KITTITAS COUNTY

TO: All Staff
FROM: Public Works Plan Review Team
DATE: September 20, 2024
SUBJECT: BL-24-00019 Moore

RECORD OF SURVEY

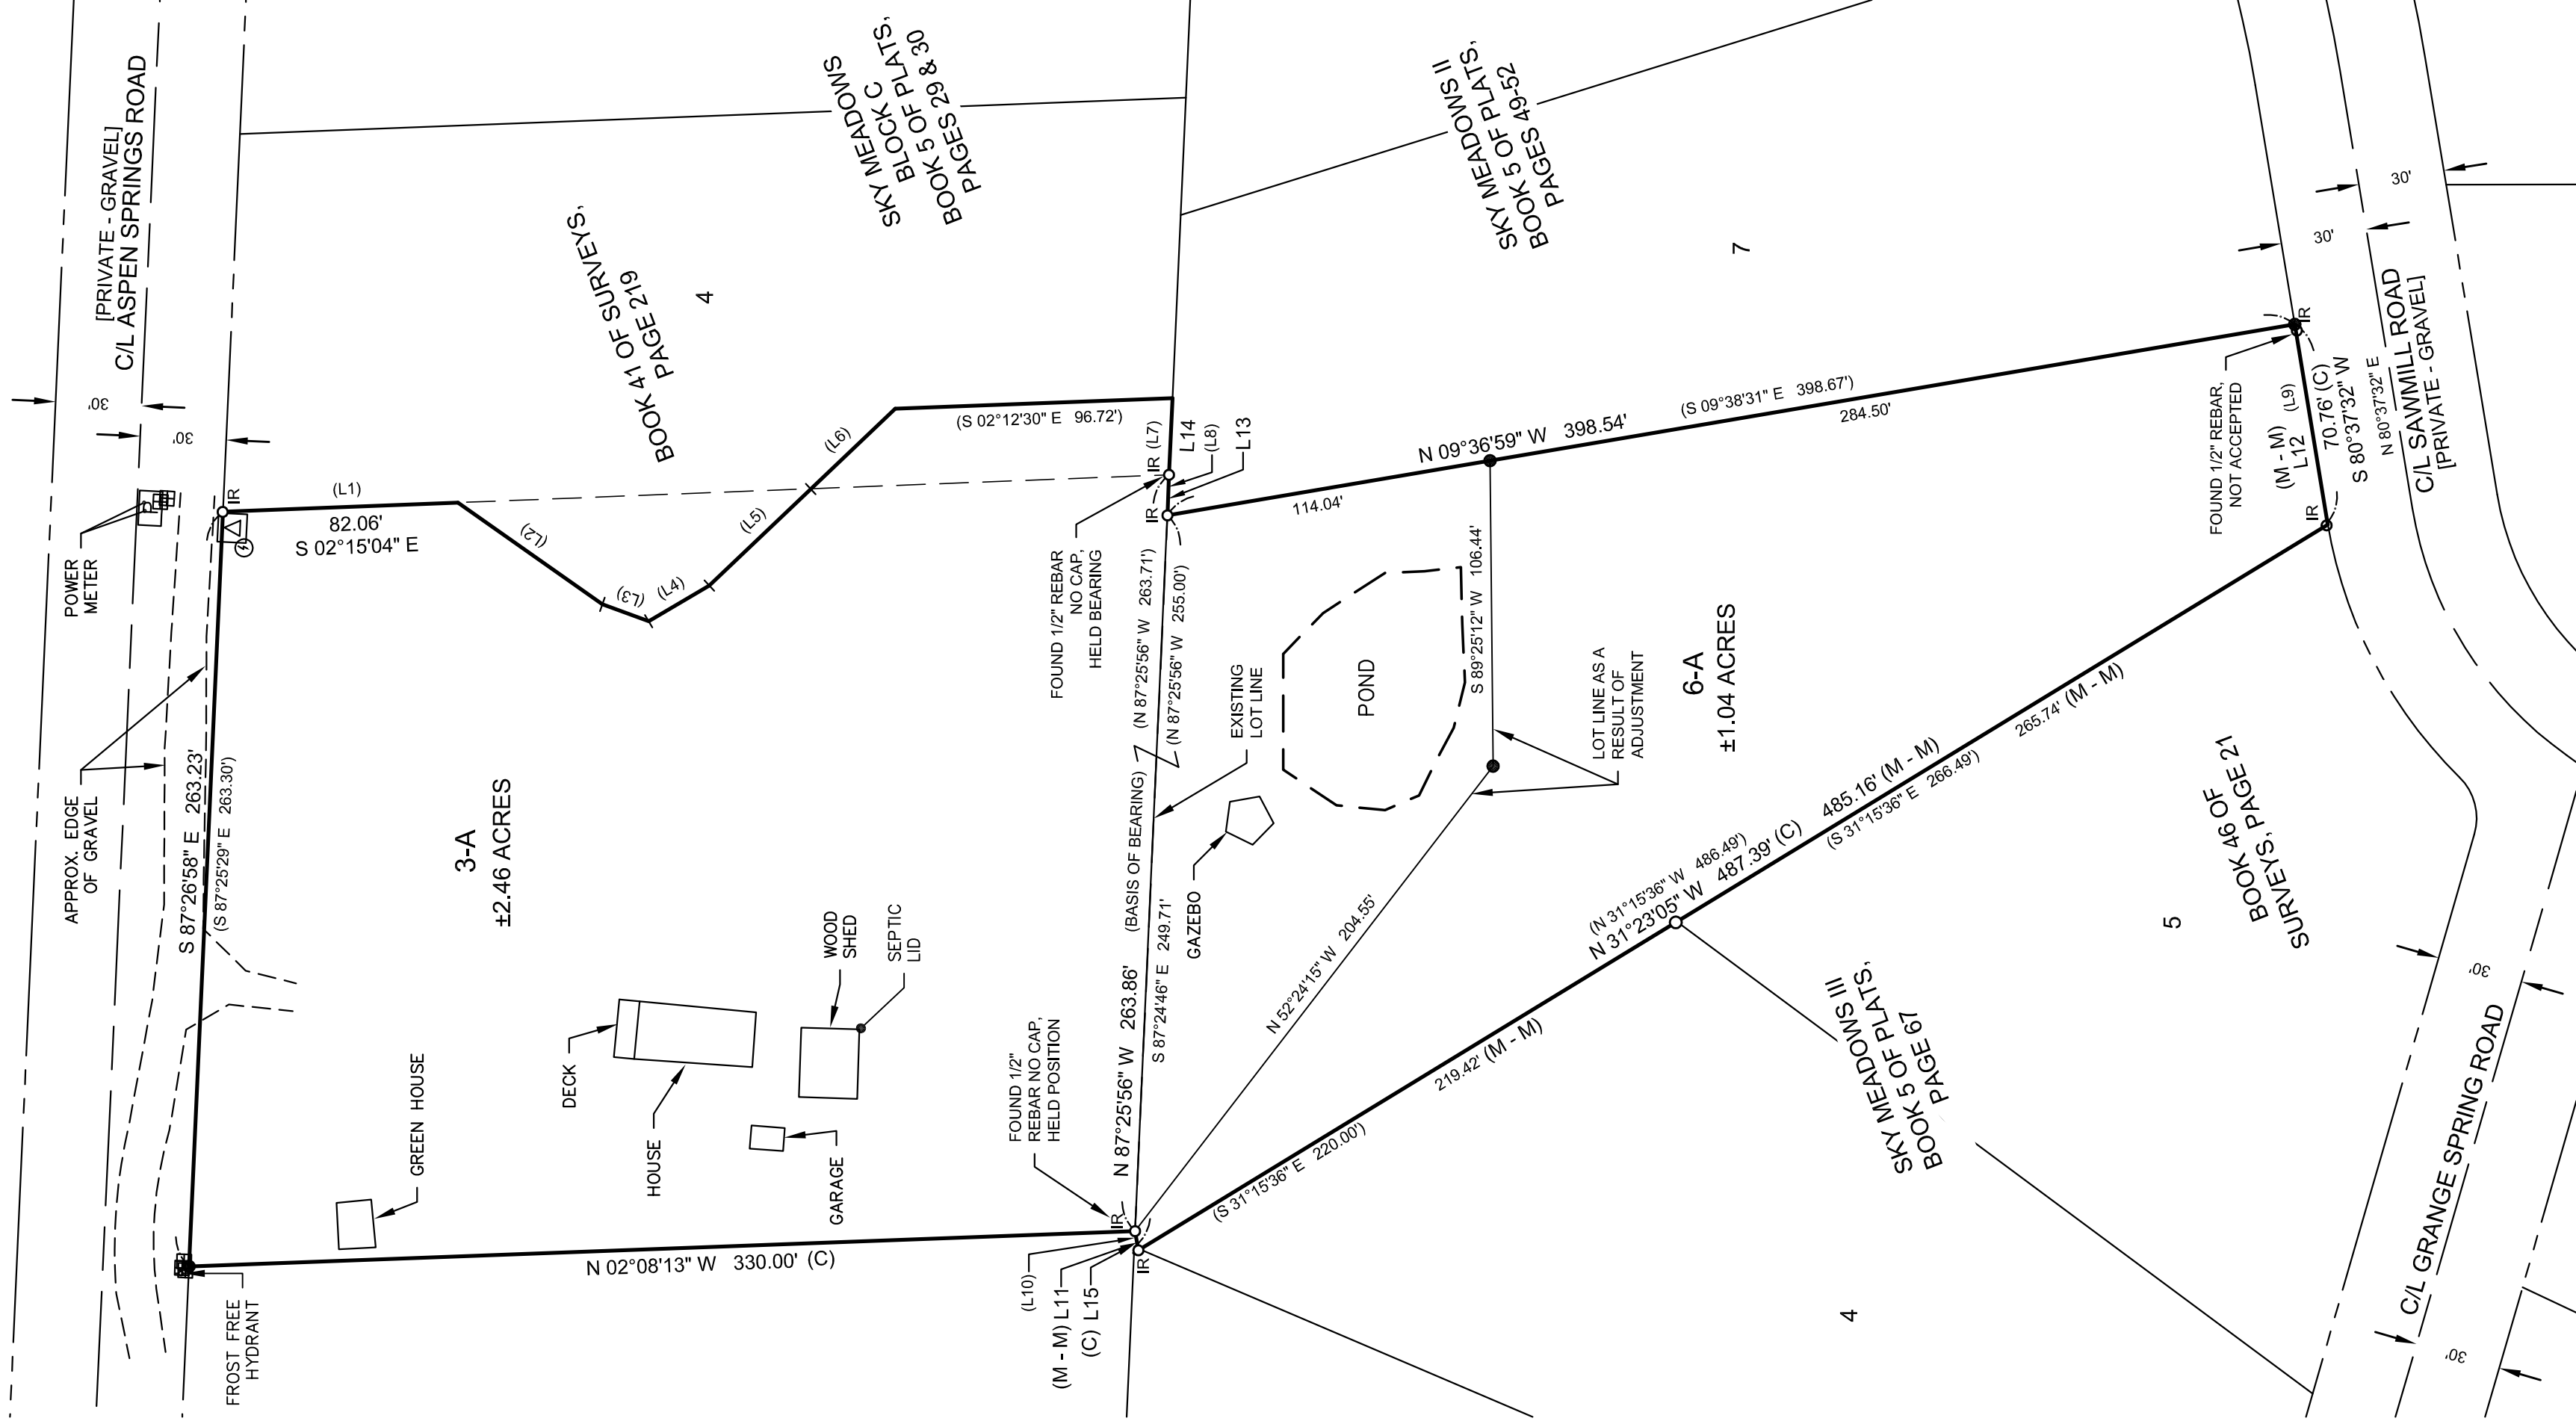
SURVEY	<p>Comments reserved until final survey (KH)</p> <p>UPDATE 10/01/2024</p> <ol style="list-style-type: none">1. The bearing and descriptions for all boundaries should be re-reviewed by the applicant. There are multiple issues including: adding up distances that do not match total line length, unclear relationships between calculated, measured and record, and record distances not being in brackets. Please make it clear for sensible retracement of the survey. Also ensure that final boundaries as shown clearly match with the lot closure report. Some record bearings and distances do not match the legal description. This may be an error, or may be referencing a different record. If it is a matter of different record, the record documents referred to shall be clearly noted.2. All roads should include ownership and surfacing.3. New legal descriptions appear to be a mix of record info and measured info.4. Detail purpose of 2 lines shown along West line of Lot 6-A. (JT)
